**Subject:** Re Your Reference TR010018

We write following receipt of your letter dated 27<sup>th</sup> October 2015 in relation to the above. The non material change in relation to the Mill Common Car Park, Mill Common, Huntingdon which I manage on behalf of the trustees fall under reference DR1.08. My email exchange with Kara Connon at Jacobs is copied below. Following receipt of Kara's email dated 16/9/15 I queried with her the disparity in relation to the "After" extract from proposed General Arrangements Plans Sheet HT 2 and Land Plans Sheet 34 copied below. If you look at the plans the Land Plan isn't in line with the General Arrangement Plan which we agreed within the Statement of Common Ground.

#### Description of Change DR1.08

**REALIGNED MILL COMMON
WORK NO. 37 - WORKS
PLANS SHEET NO. 29**

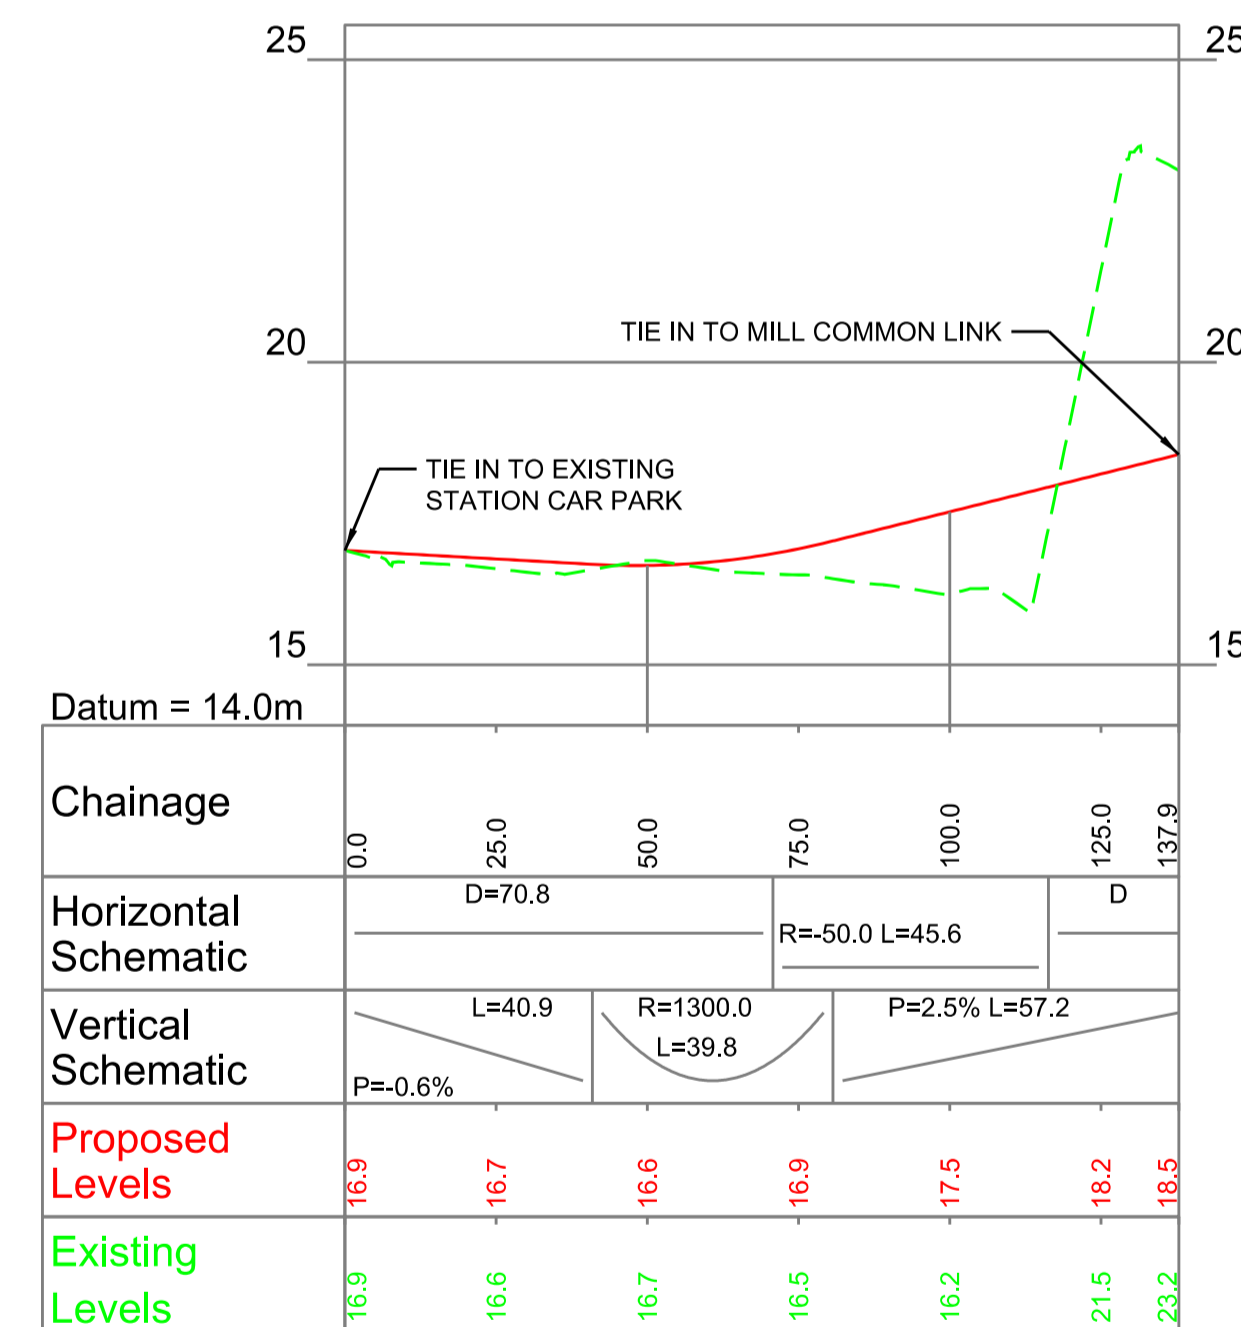
4. De-Trunking Plans Regulation 5(2)(o) Sheet 5 of 15 (page 69)– This plan still shows the revised alignment of Mill Common running straight through the car park and not what was agreed in the statement of common ground.

5. A14 Cambridge to Huntingdon Improvement Scheme Environmental Statement 2014 sheet 3 of 4 and sheet 4 of 4 (pages 80 to 81) - Again this plan shows the revised alignment of Mill Common running straight through the car park.

The current change DR1.08 in relation to the landtake does show a greater extent of pink than it needs to. The design/ layout drawing shows the correct layout as we discussed, the detail design stage will resolve the access to the car park.

The scheme does only take the original 4 parking spaces and once the detail design stage is complete the boundary line would sit just behind the proposed footway running adjacent to the realigned Mill Common road. The exact position would be dependent on the detail design and the access arrangements agreed with yourselves.
